Online Comment

Application H23-0313-25
Location Land At Peartree Hill Road Whaplode Drove Spalding PE12 0SL
Proposal Provision of new poultry unit & associated works

Name Holbeach Parish Council - Full Council
Address Holbeach Parish Council Coubro Chambers, 11 West End Holbeach
PE12 7NH

Holbeach Parish Council - Objection to Planning Application H23-0313-25

PROPOSED:
Provision of New Poultry Unit & Associated Works
Proposed Access Plan and Visibility Splay

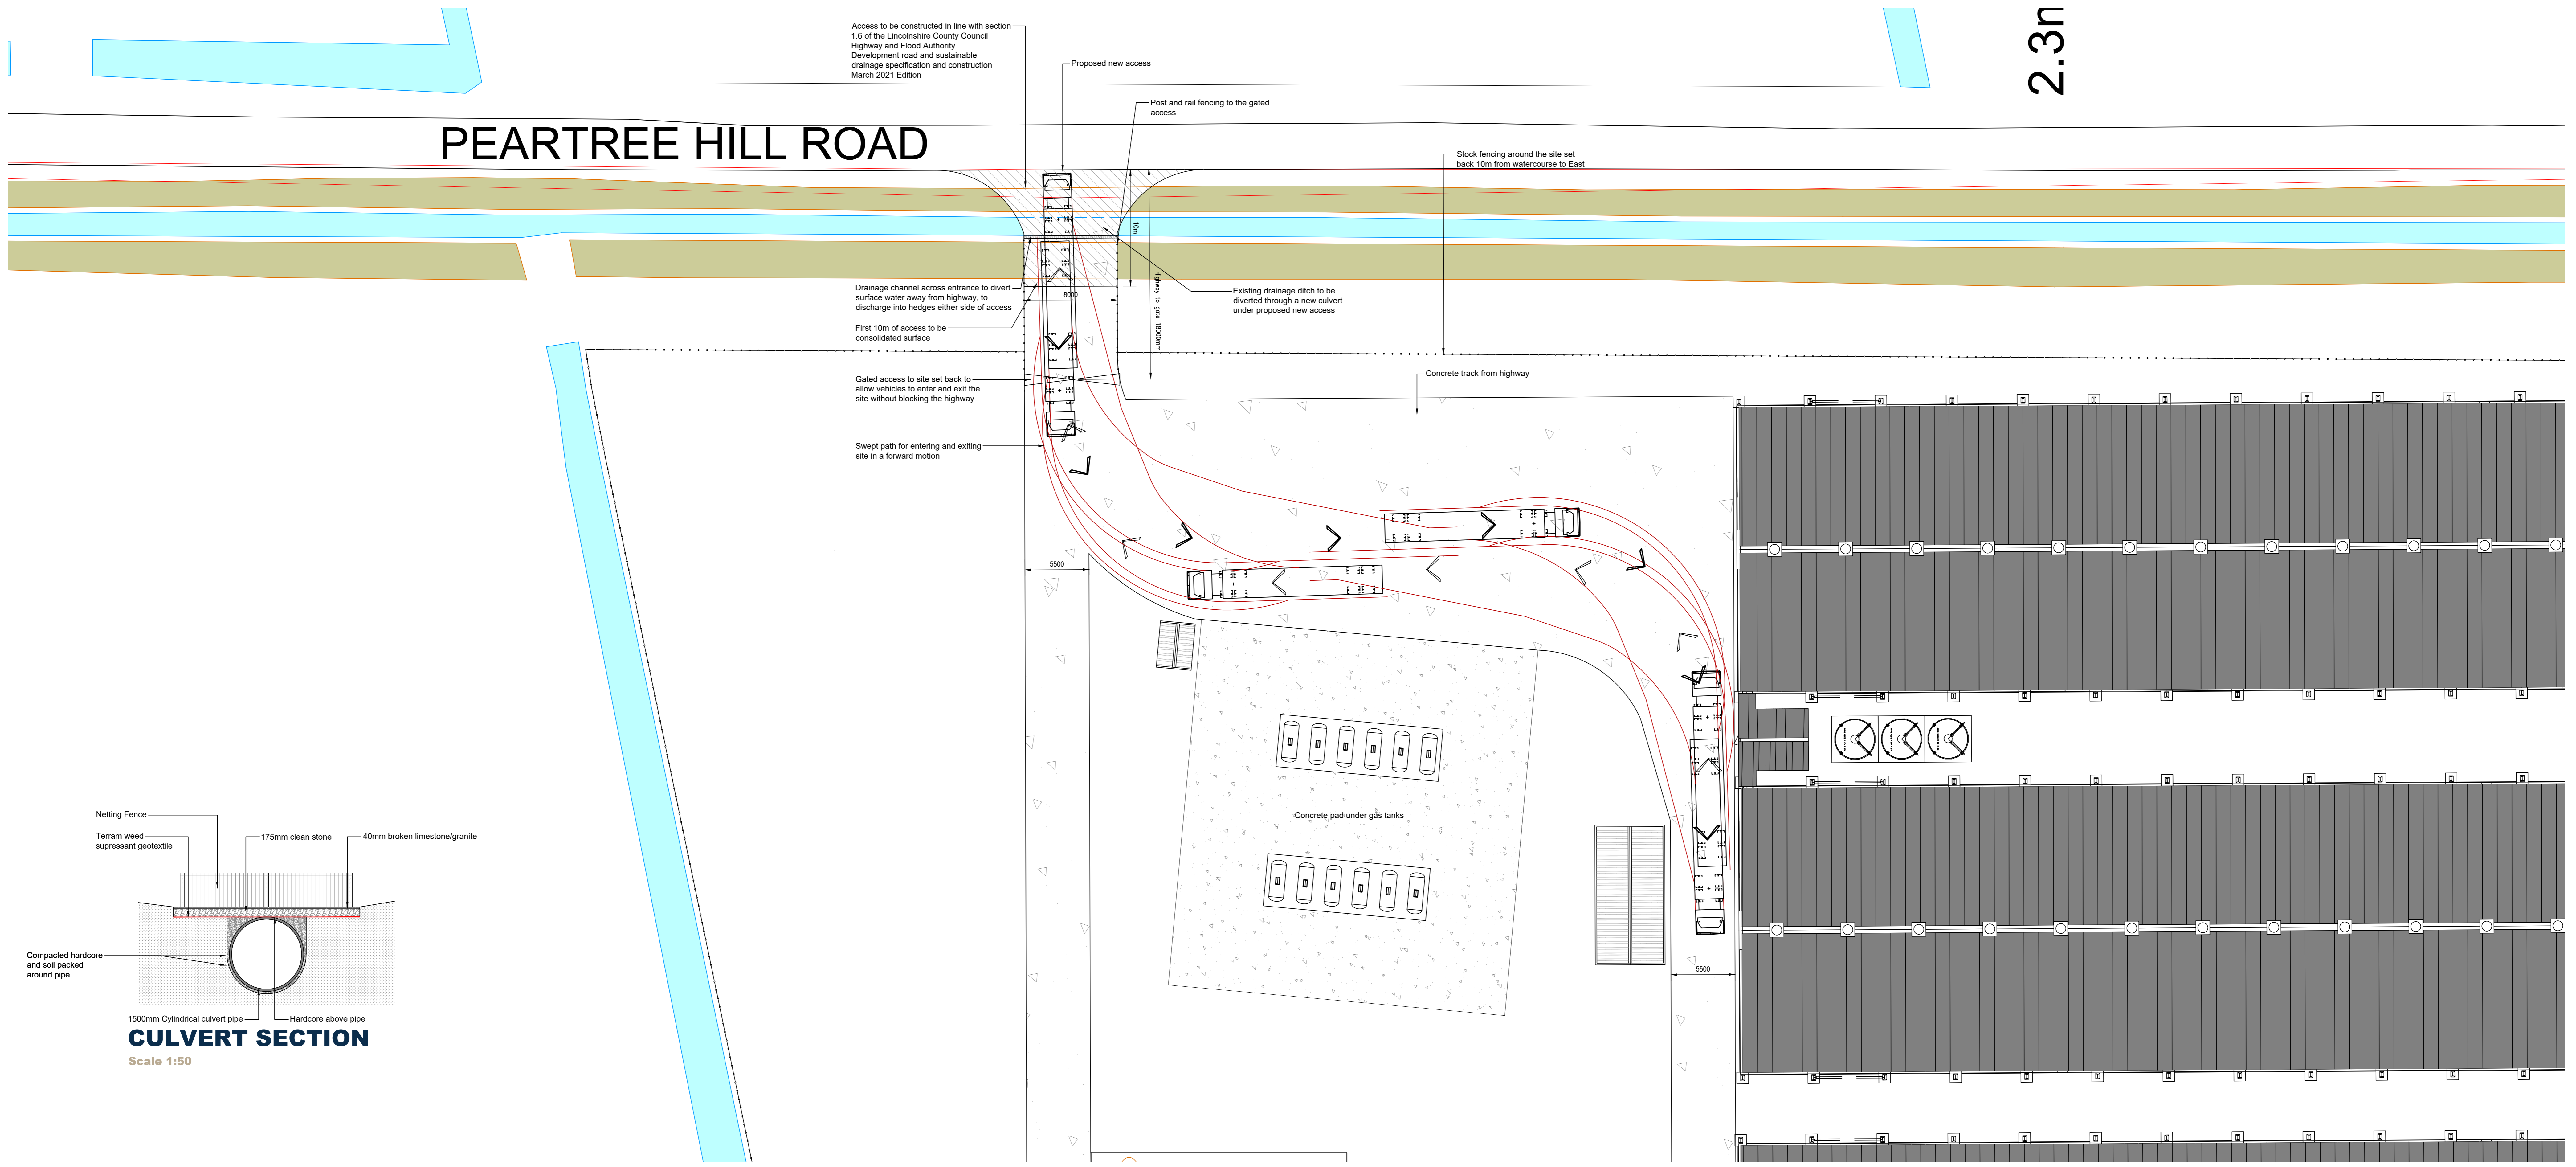
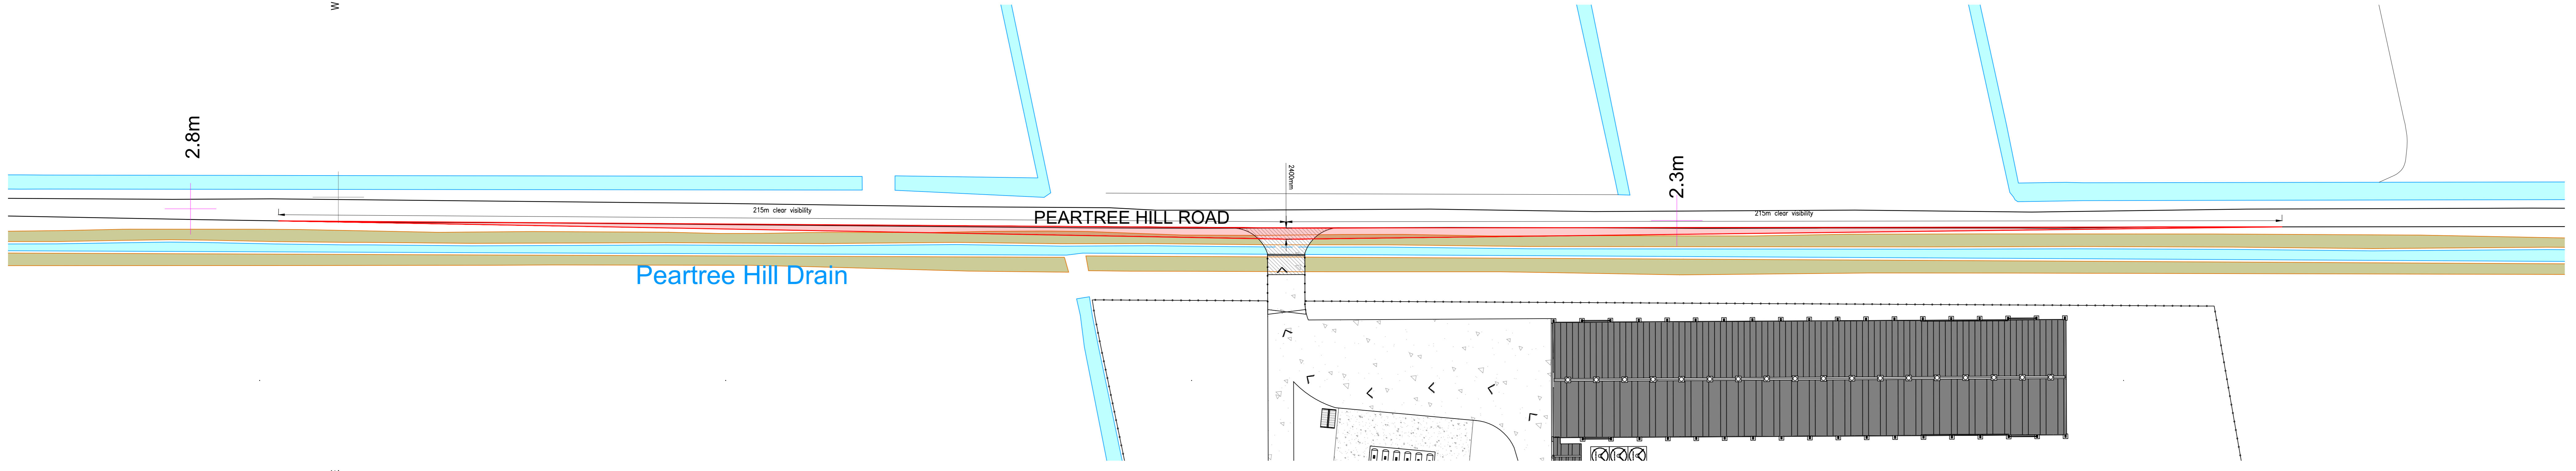
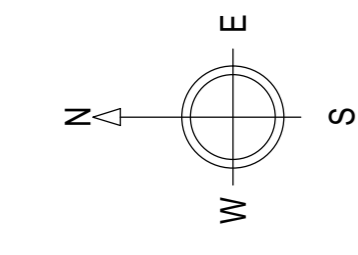
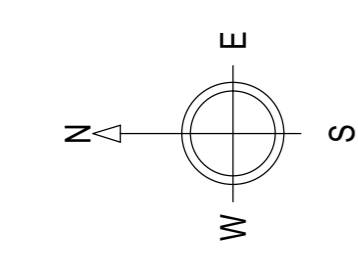
- Access Road Unsuitability: Pear Tree Hill Road is narrow and visibly degraded. It cannot support the weight and frequency of HGV traffic this proposal would generate.
- Network Fragility: Surrounding roads show subsidence and cracking. These routes were not built for sustained heavy goods movement.
- Incomplete Assessment: The applicant's transport report lacks key data, including California Bearing Ratio (CBR) tests, essential for evaluating road resilience.
- Traffic Volume: Estimated 2,884 HGV movements annually- likely conservative- would accelerate road damage and impose repair costs on local authorities.
